TOWN AND COUNTRY PLANNING ACT 1990 OUTLINE

Reference:	H21-0410-17	Date of Decision:	14th July 2017
Applicant:	Mr M Reims 2 Common Way Tydd St Mary Wisbech Cambs PE13 5QH		
Location:	Rectory Road Tydd St Mary Wisbech Cambs		
Description:	Residential development - single dwelling

Project RESIDENTIAL DEVELOPMENT. OFF BECKTOR ROAD TPOD ST WPK. WEEBACH CAMPS, FIELD 50A.		Drawing 4 BEDROOM HOUSE FLOOR PLANS & ELEVATIONS. - PROPOSED.	
Drawn	Drawn	Job Ref.	Drawing No.
APRIL '17.	S.L.D.	2967-16.	03.

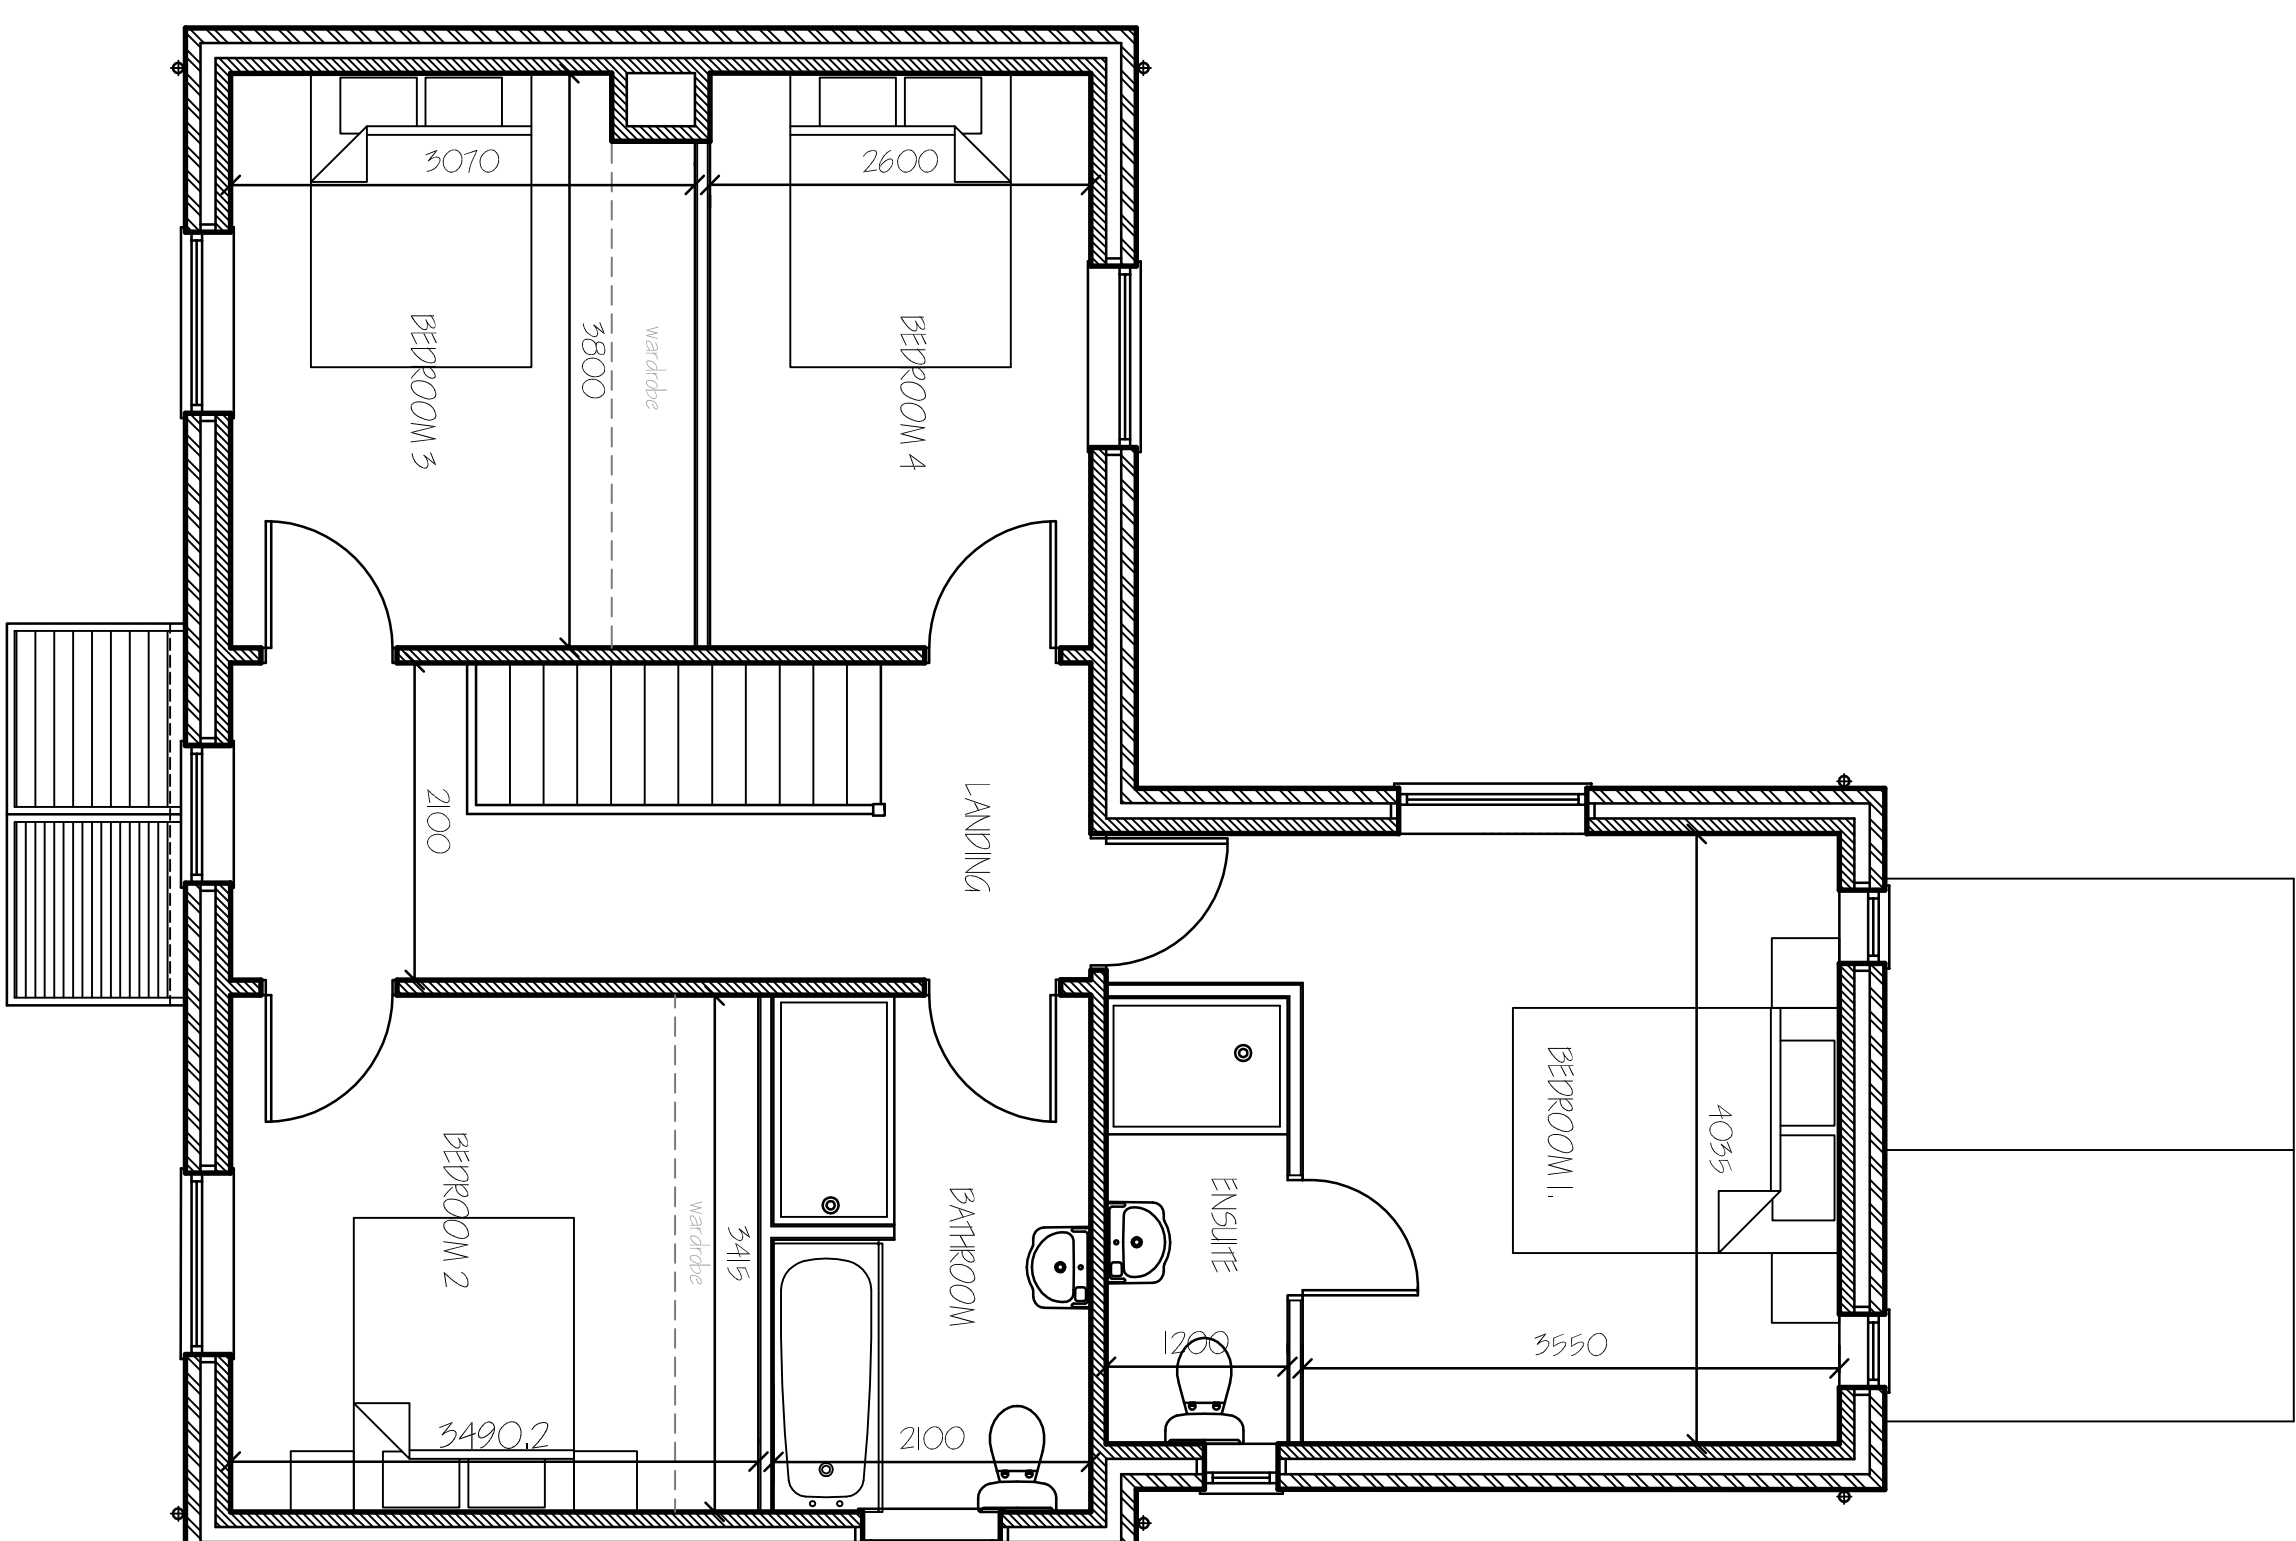
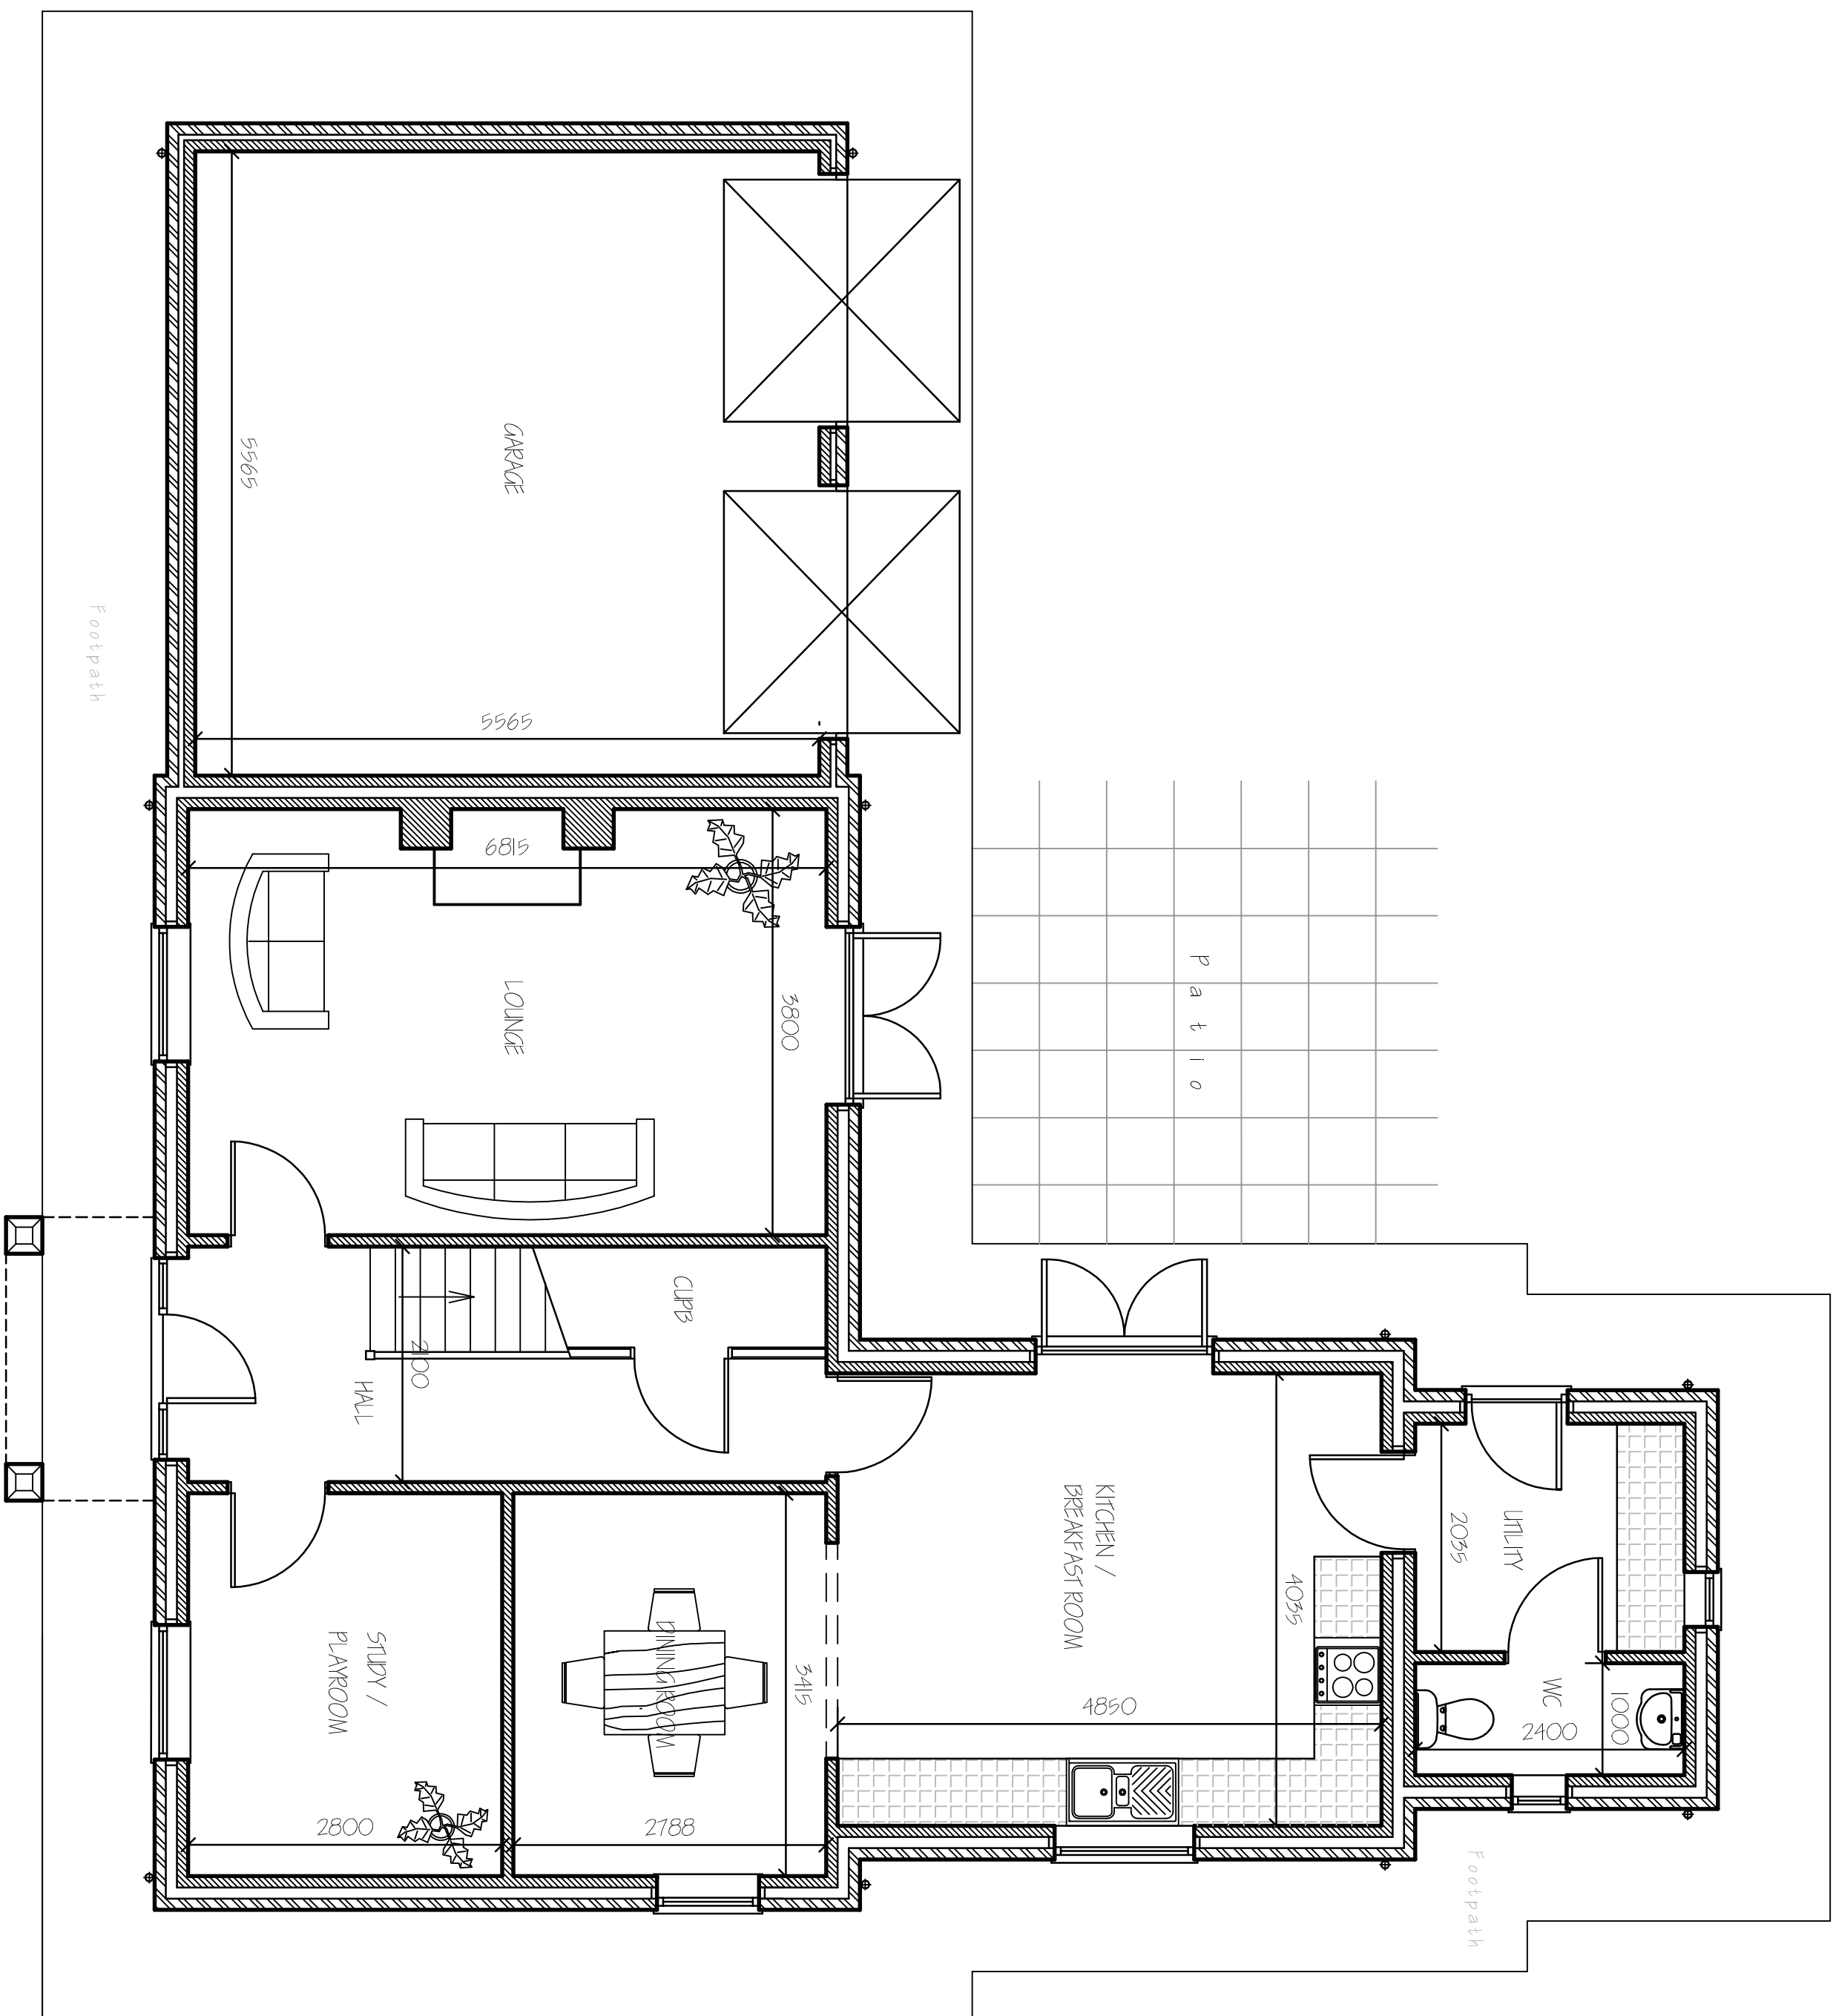
The appearance of the property should reflect traditional vernacular and the character of existing development along Rectory Road within Tydd St Mary Conservation Area. The property should also be designed so as to not materially harm the amenity of neighbouring residents in terms of overlooking, overbearing effect, overshadowing, etc. The indicative dwelling is not wholly satisfactory in this respect.
